**Date:** 31 May 2022

**Planning Act 2008**  
**Awel y Môr Offshore Wind Farm Limited**  
**The proposed Awel y Môr Offshore Wind Farm Order**  
**PINS Reference: EN01011**

Awel y Môr Offshore Wind Farm Limited (the Applicant) encloses the documents mentioned in the table below in response to advice issued by the Planning Inspectorate on 18 May 2022 under section 51 of the Planning Act 2008. Where appropriate the Applicant also provides specific responses in the table below the points raised by the Planning Inspectorate in the section 51 advice.

DRAWING NUMBER: 004262354-06
 APFF: 5 (2) (k)
 Sheet No: 3 of 10

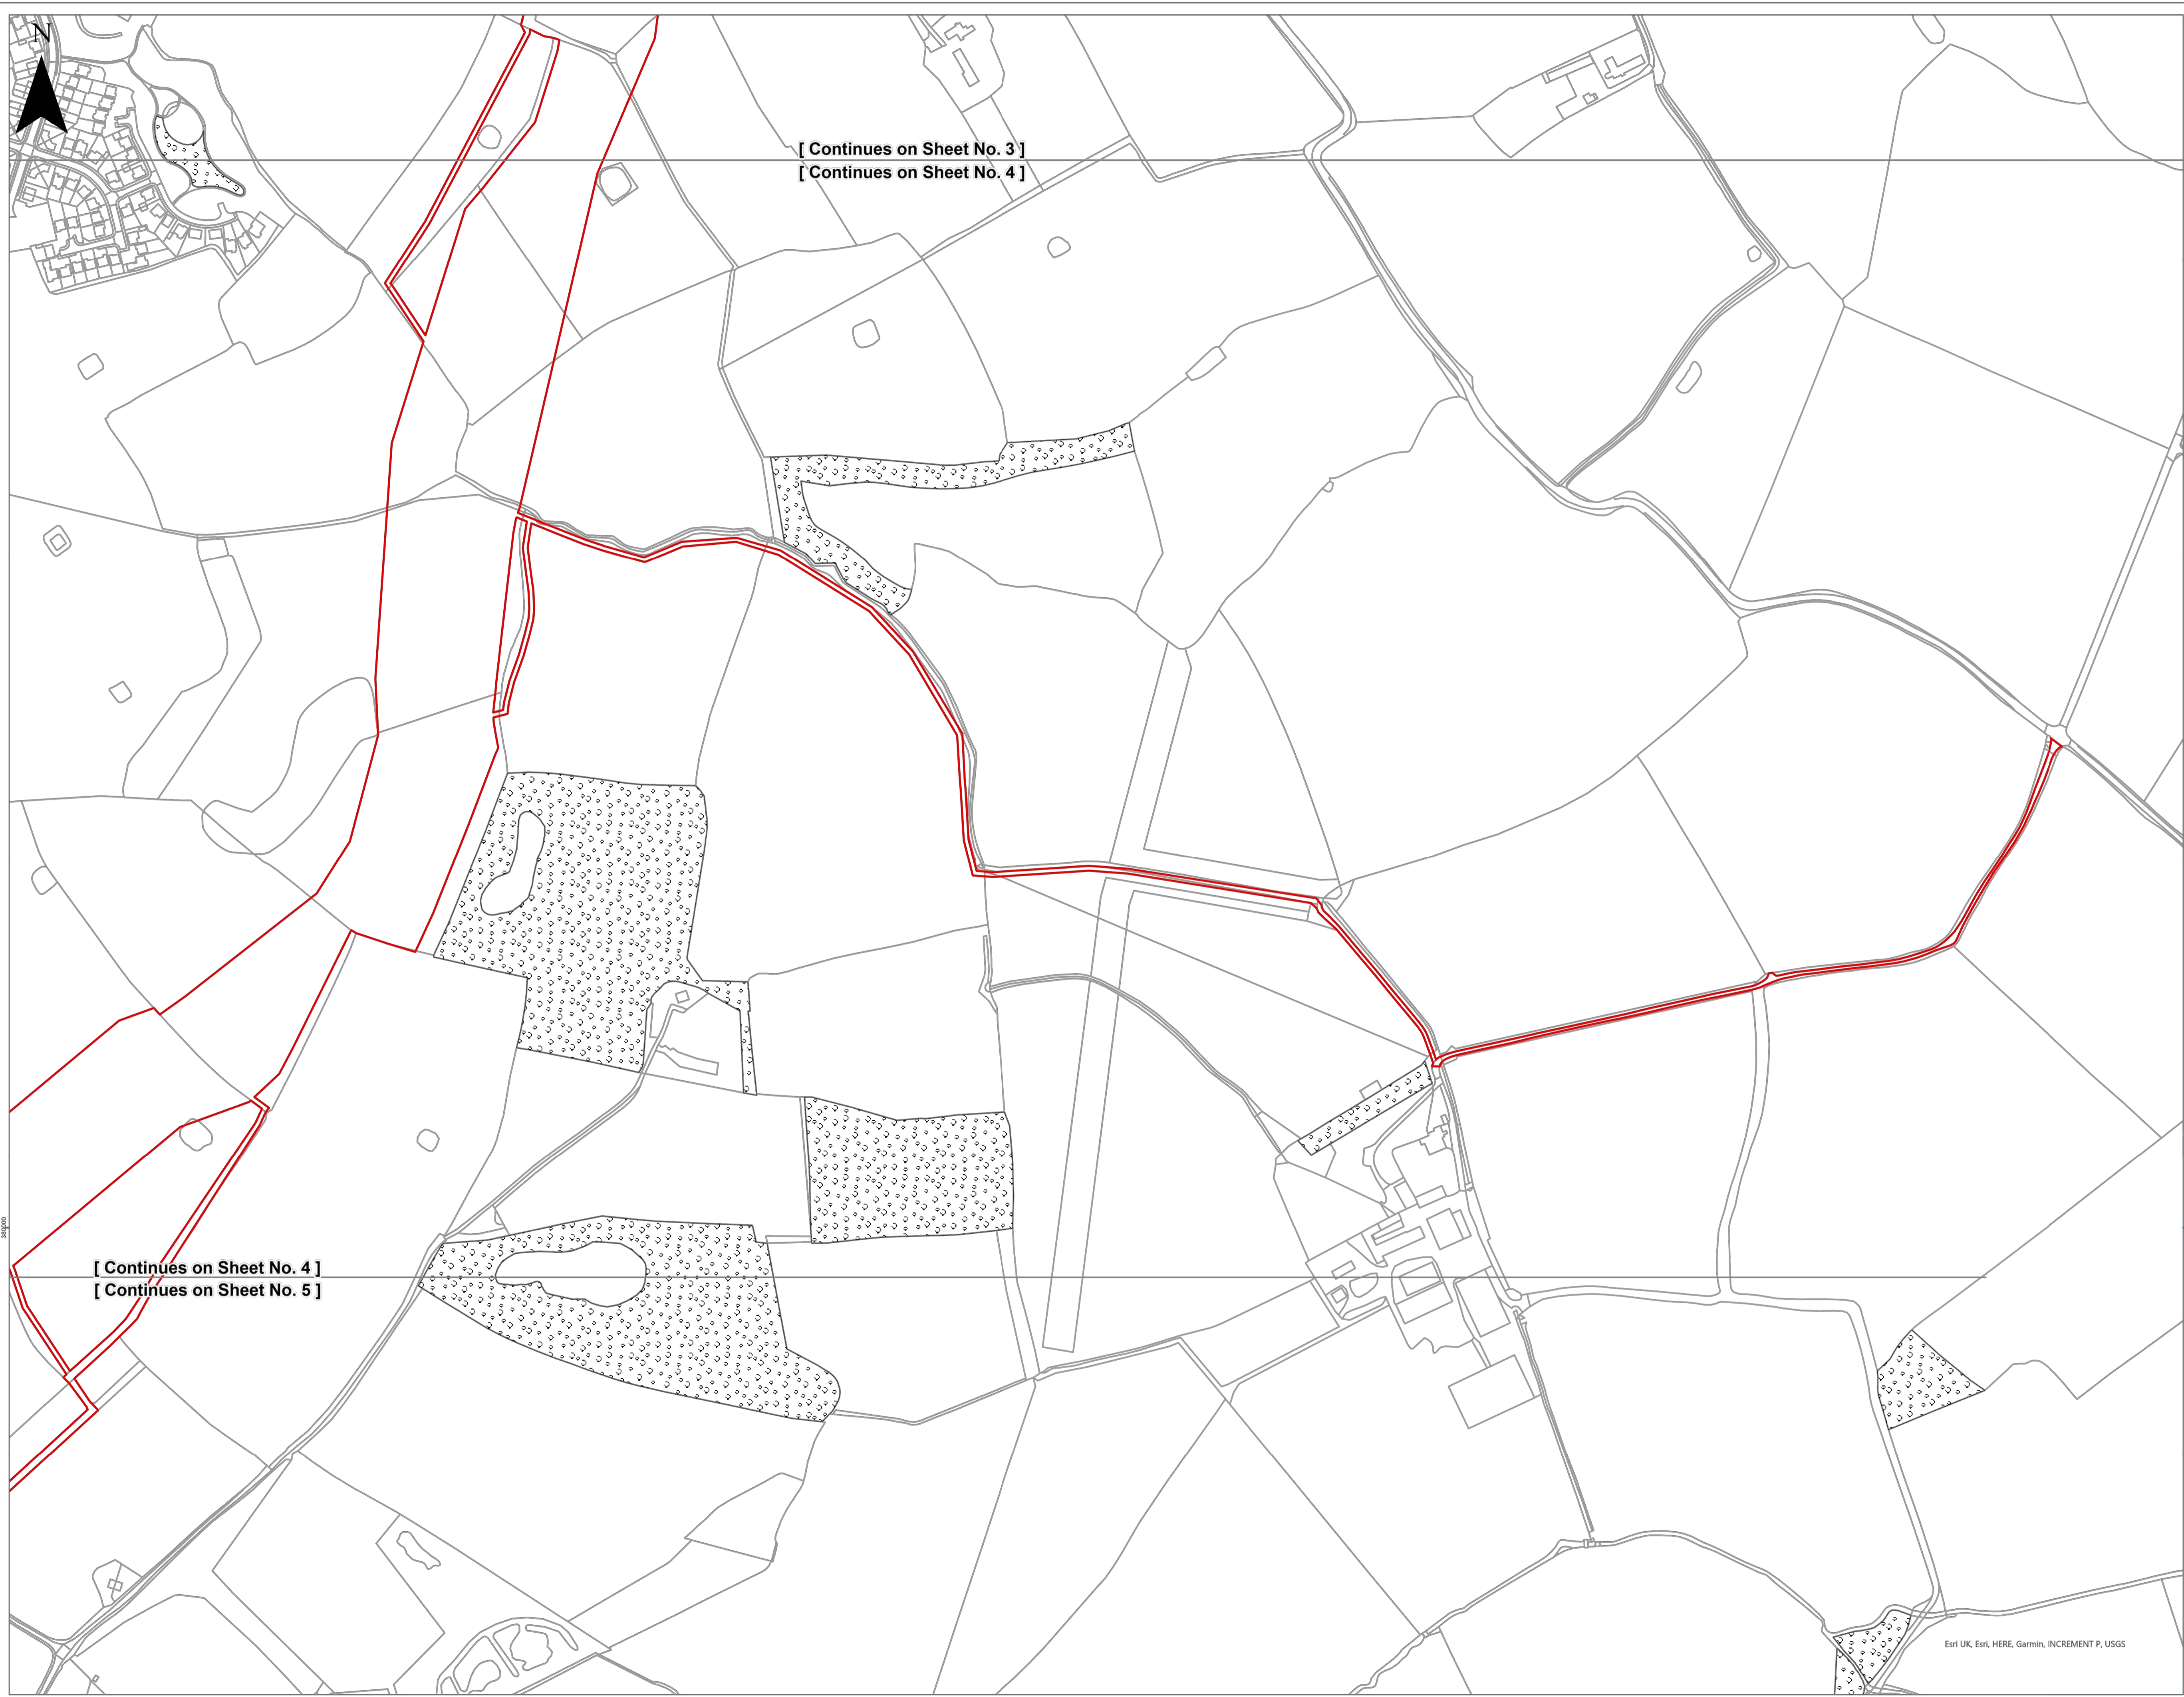
Ensure all plots are shown clearly on the plans. For example, Plot 113 on Sheet 3 of 10 of the onshore Land Plans is not discernible.	The Applicant has reviewed the land plans and added additional inset plans to assist with discerning particularly small plots. Specifically in respect of Plot 113, the inset plan has been extended to incorporate this plot.
In the Works Plans, 'Work No 23' should be labelled on Sheets 9 and 11.	Two additional labels with "Work No 23" have been added on the relevant pages of the Works Plans.
The legend in the Street Works and Access Plan refers to Schedule 4 instead of Schedule 3 of the dDCO.	The legend has been updated to reflect the correct Schedule.
Footpath names on the Temporary Stopping Up of Public Rights of Way Plans could be enlarged.	The size of labels for both the footpaths and the extents of public rights of way have been increased from 16pt to 24pt.

DRAWING NUMBER: 004262354-06
 APPF: 5 (2) (k)
 Sheet No: 9 of 10
 SCALE: 1:2,500 PLOT SIZE: A1 DATUM: OSGB 1936 PROJECTION: BNG

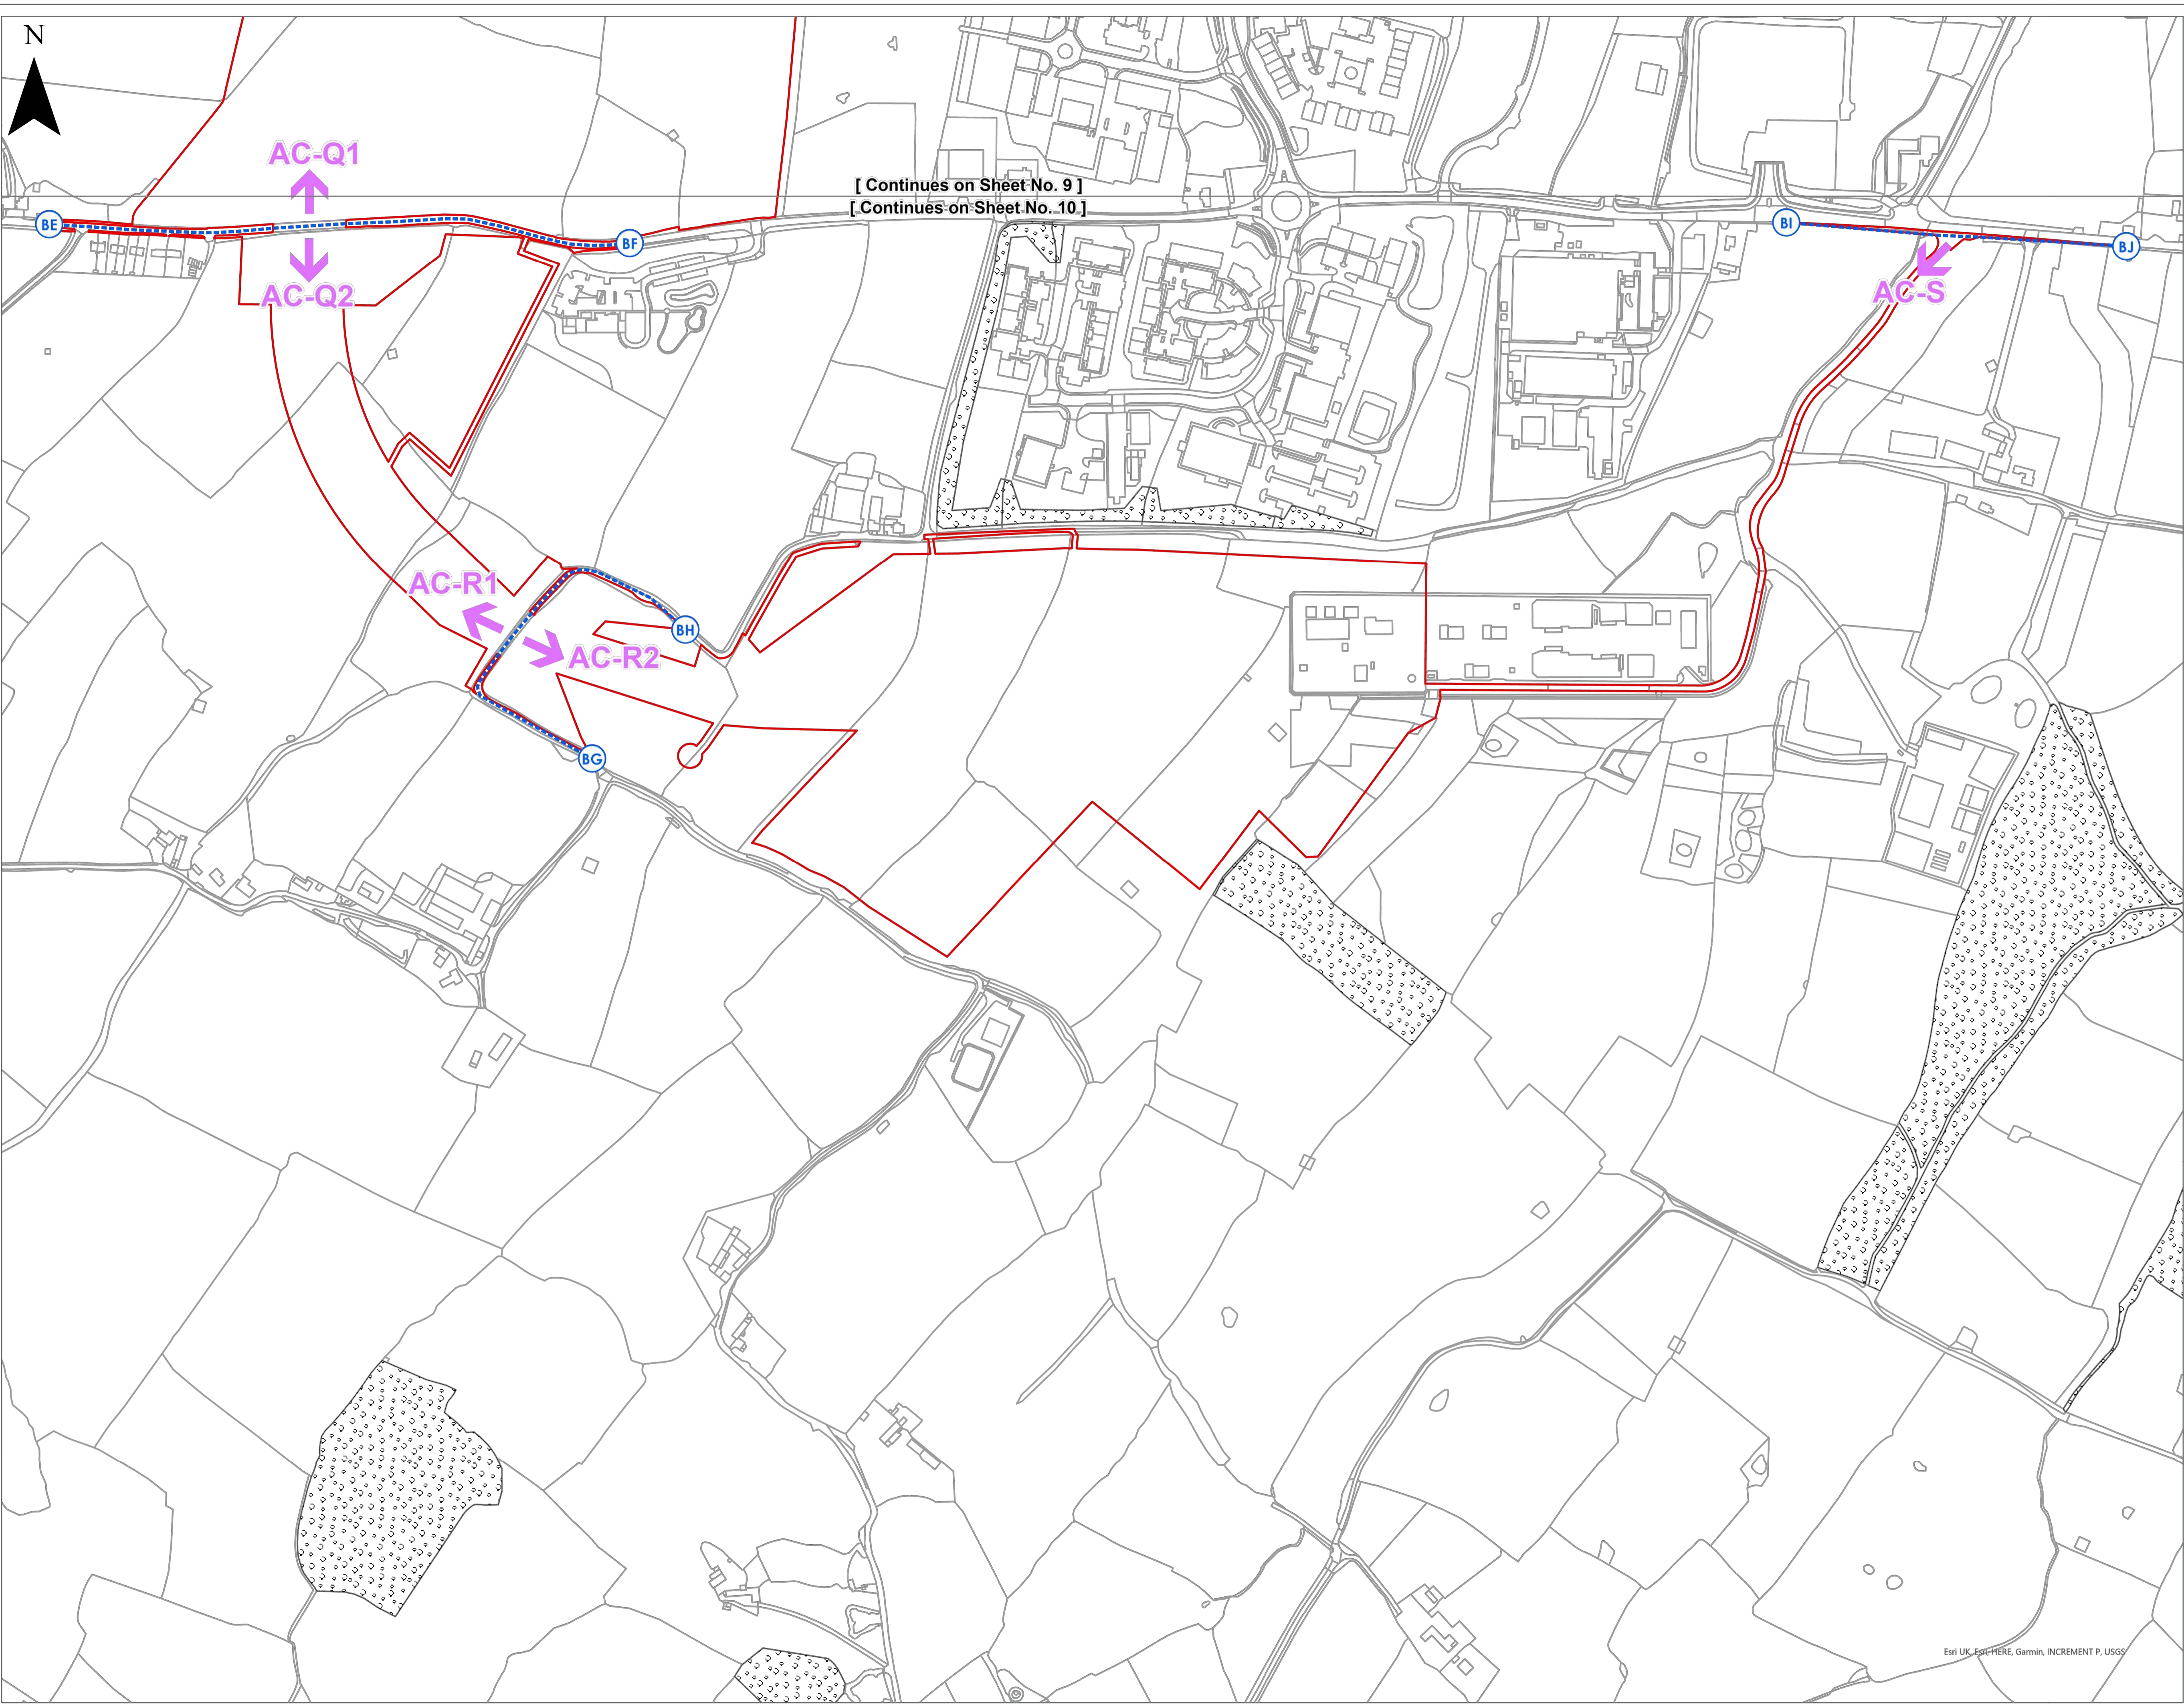
<p>Schedule 3 – points BI and BJ shown on the last page of the street works and access plan have been omitted.</p>	
<p>Schedule 4, columns 1 and 2 – inconsistencies between the information in these columns and the information shown on the temporary stopping up of public rights of way plan, and the naming of the plan is the ‘temporary stopping up of public rights of way plan’.</p>	
<p>Schedule 5, column 1 – References to AC-Q do not appear on the street works and access plans. ‘AC-Q1’ and ‘AC-Q2’ appear on the plans but are omitted from Schedule 5. It would also be helpful to identify the relevant sheet numbers.</p>	
<p>In addition to the above, the Applicant should undertake a general review of the dDCO for consistency, grammar and punctuation.</p>	
<p>It would be helpful for the Applicant to provide the Inspectorate with a full set of hard-copy visualisations at the correct viewing size relating to: a) the Seascape, Landscape and Visual Impact Assessment; and b) the Landscape and Visual Impact Assessment, to assist the Examining Authority, when appointed, during any site visits.</p>	<p>The Applicant can confirm that the requested full set of hard copy visualisations will be provided.</p>
